**ADC Planning Consultation
Response from the Historic Buildings Adviser**

Application Number	A/51/12/DOC
Address	The Dower House, Angmering
Description	Approval of details reserved by Conditions 5 and 6 following approval of A/147/11/L
Case Officer	Peter Cleveland
Site Visit

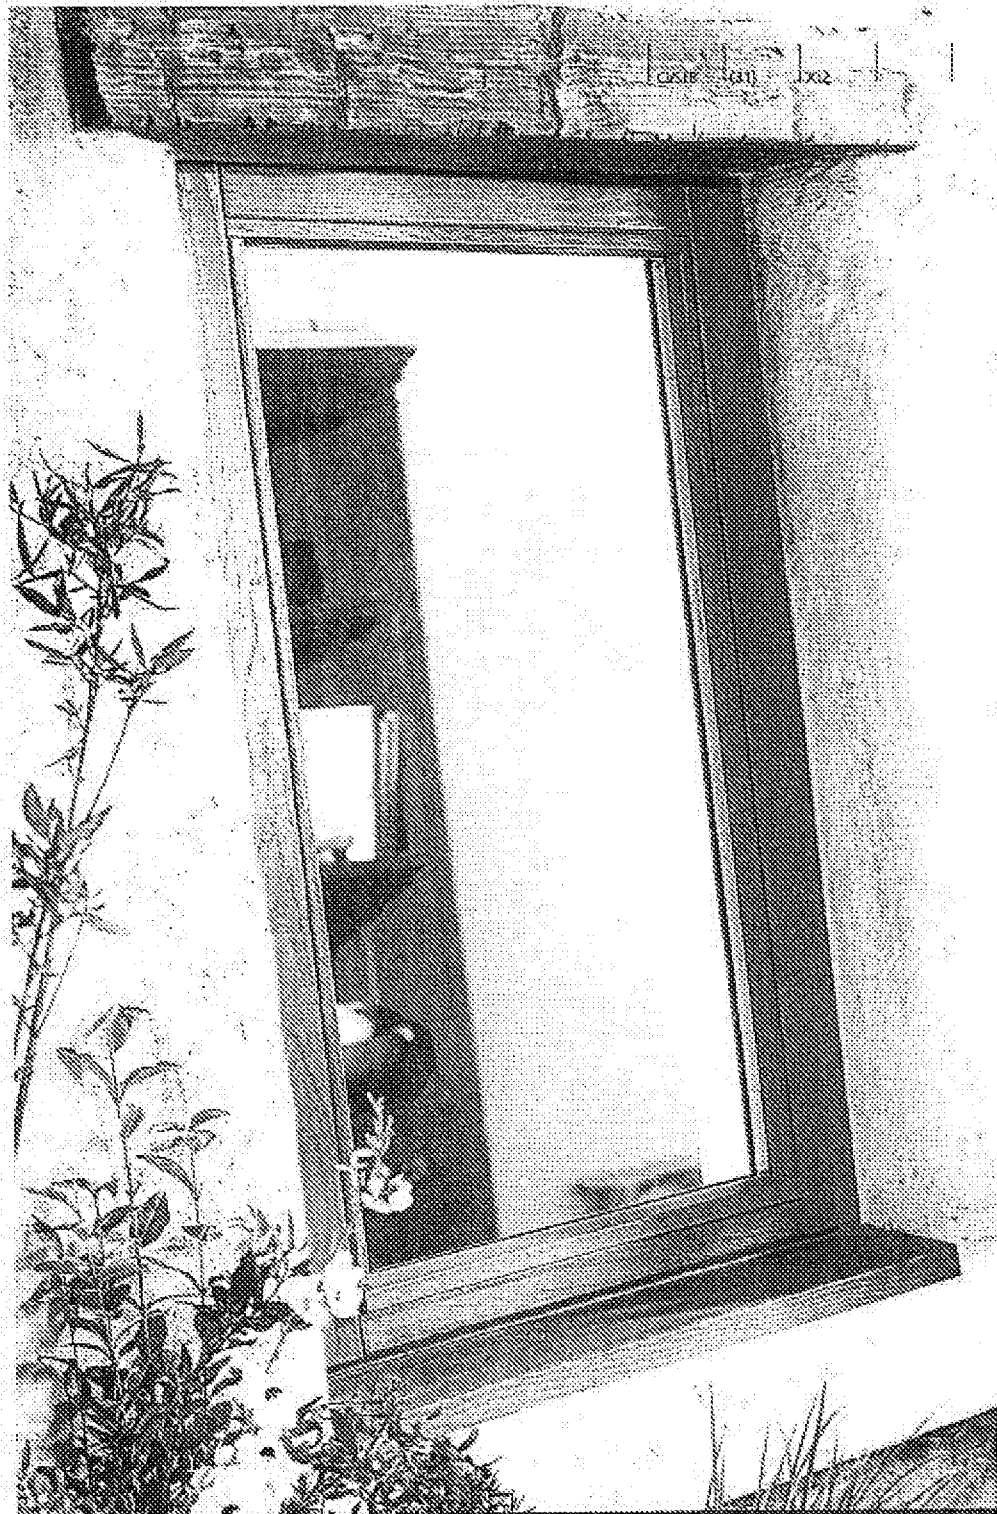
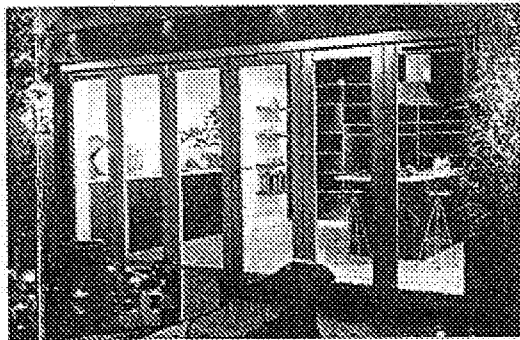
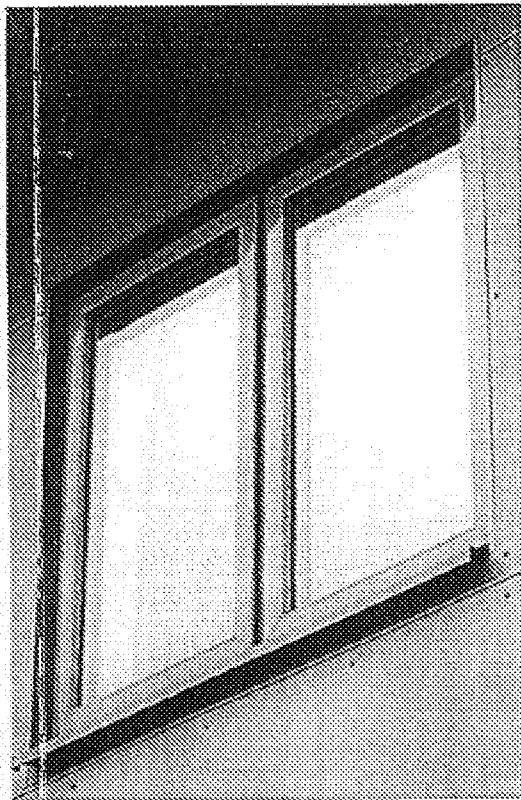
The approved scheme shows full height casements with light framing, however the window details appear to refer to the use of storm casements with top opening vents. This type of window design is overly heavy and not normally appropriate for use on listed buildings. Ideally the windows should be a flush timber casement and more in accordance with that shown in drawing no: JC/11/07A of the approval.
